TERRESTRIAL ECOLOGY ISSUES WITHIN THE RESPONSE TO SUBMISSIONS DOCUMENTATION FOR THE NARRABRI GAS PROJECT.

Review of biodiversity matters within Response to Submissions
Expert Report on adequacy of response to issues within submissions from Upper Mooki
Landcare Inc

Review: Biodiversity issues within the Response to Submissions documentation for the Narrabri Gas Project.

Figure 5: Overall site value in rehabilitation areas compared to nearby reference sites not disturbed by the project (2013-14)

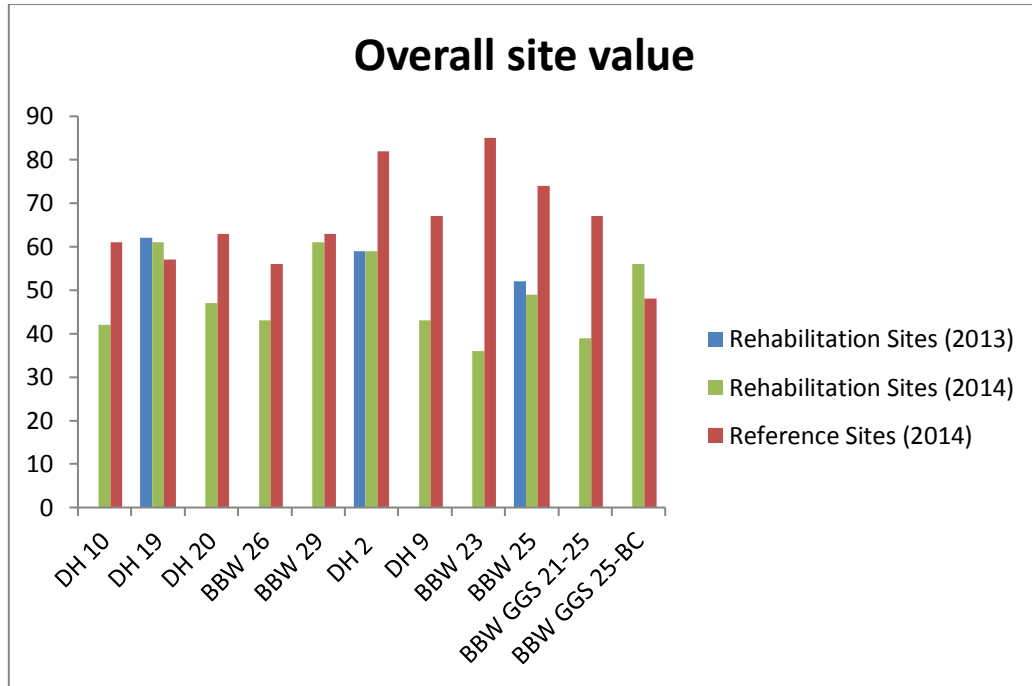
26. Santos provide no verifiable data to support this claim in the **Rehabilitation Plan** (Appendix V of EIS). The only data provided is in Figure 5 of the Plan which shows differences in 'site quality' for a number of sites, what this means is not clear. One site at the Bibblewindi shows a higher site quality than reference sites! The lack of rehabilitation success is exemplified at the Bibblewindi Spill Zone rehab. This site is undergoing intensive irrigation treatment and planting out. However, species planted in this zone are mostly sedges which do not occur in the adjacent unaffected bushland. Based on this questionable data which is not publicly available, Santos are now requesting a 17% increase in the credits generated at the sites. This cannot be supported given the data currently being collected independently.
